PLOT PLAN DRAWING CHECKLIST

PROJECT NAME: 3885 Doolittle Rd File # AL-14-017
SUBMITTAL DATE: 1/1
SUBMITTED BY: Eric VanDenHoeck EUSCJA
SUBMITTAL REVIEWED BY: _____

Special Use Map

PLOT PLAN EXHIBIT - SPECIAL USE

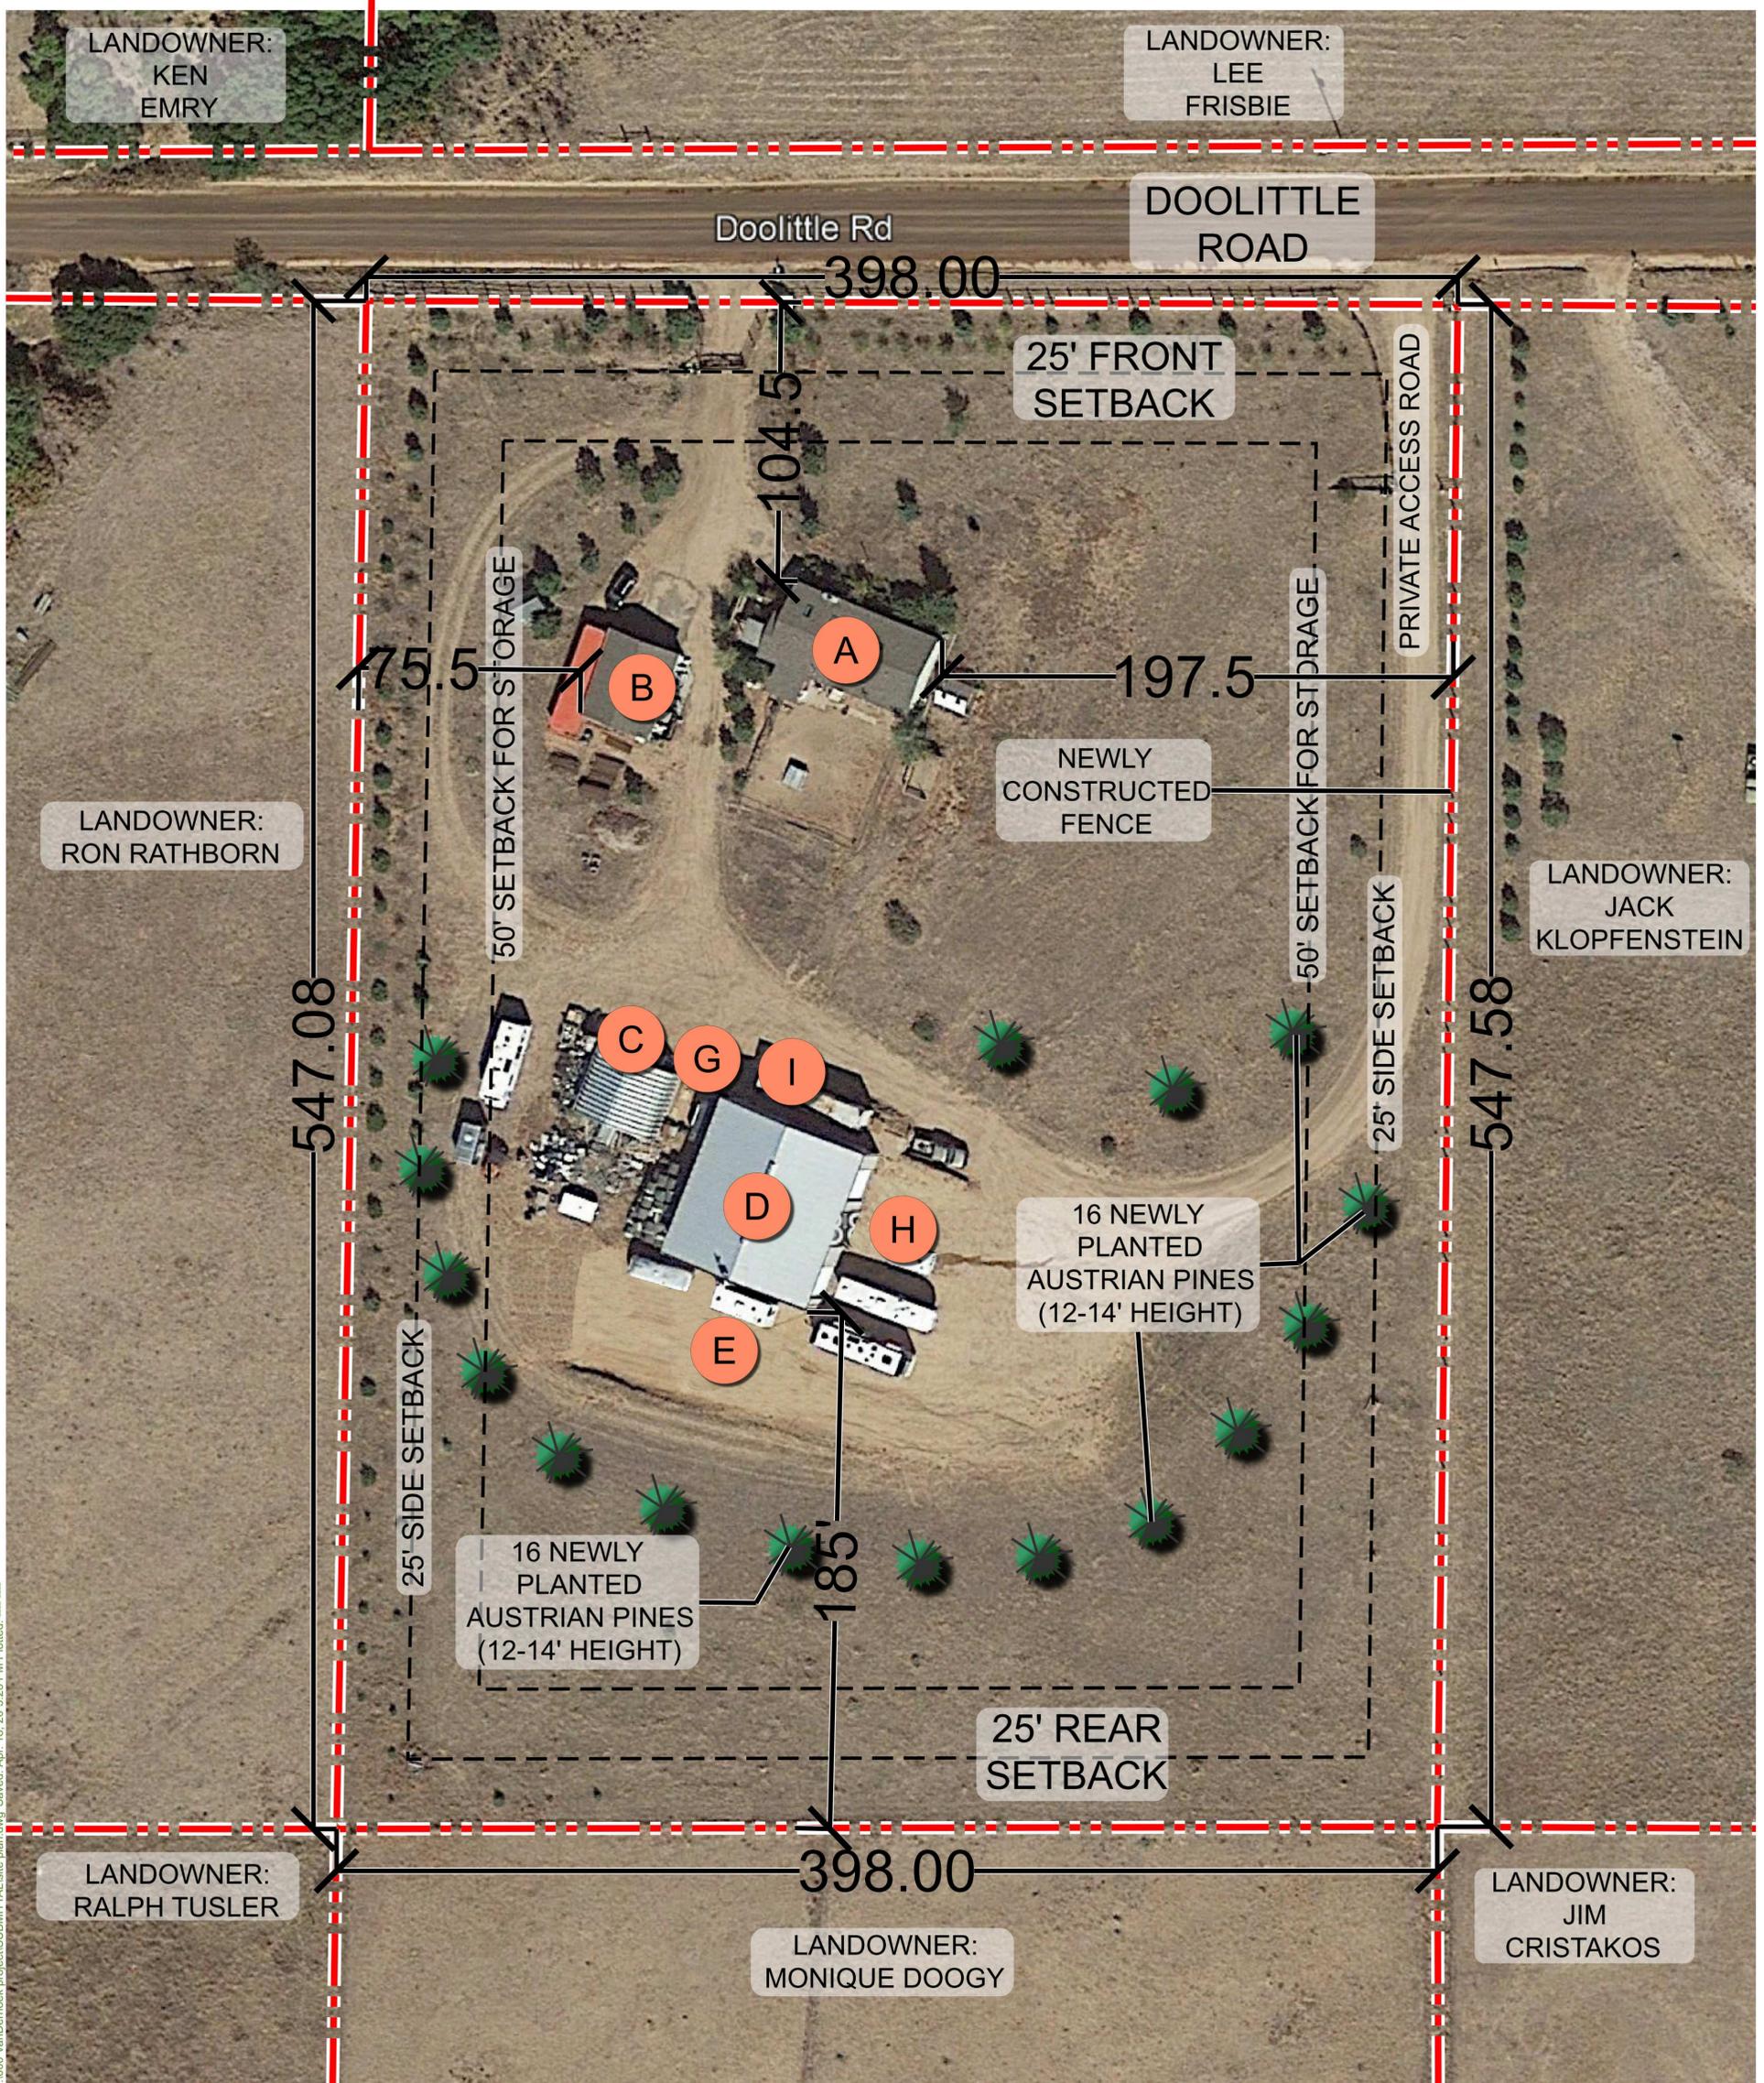
please add these items

it is unclear what is utilized for the business. Please clarify. All outside storage is to be 100% screened from view. Please provide details for outside storage areas. Please add to the LOI regarding the use of the property and outside storage/parking.
